## **PLAN REVIEW SHEET**

**Date: February 28th, 2024**

**Petition #: 2023-015**

The site is located at 2501 Wilkinson Boulevard, adjacent to the proposed LYNX Silver Line light rail transit corridor and Remount Road station. The light rail corridor necessitates a minimum ROW width of 130 feet.

**CATS RAIL RIGHT-OF-WAY PORTAL**  
SCALE: NTS

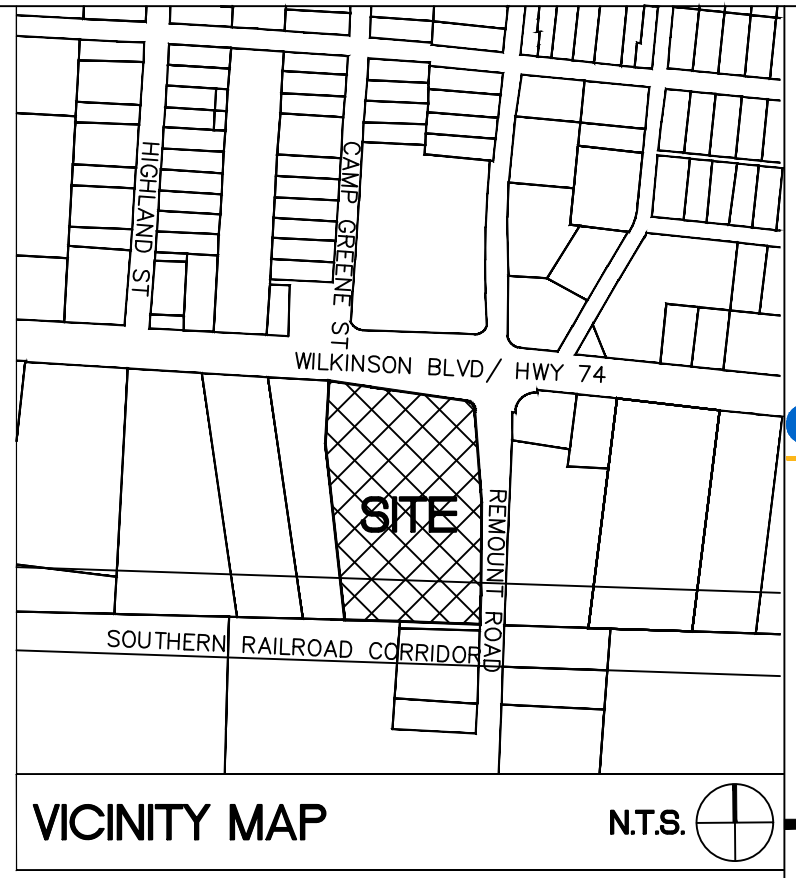
- a. Dimensions of the station's portal/tunnel/opening necessitates a minimum clearance for the safe operation of the light rail system consistent with the existing LYNX Blue Line light rail infrastructure. Details of the design will be coordinated in the land development process.
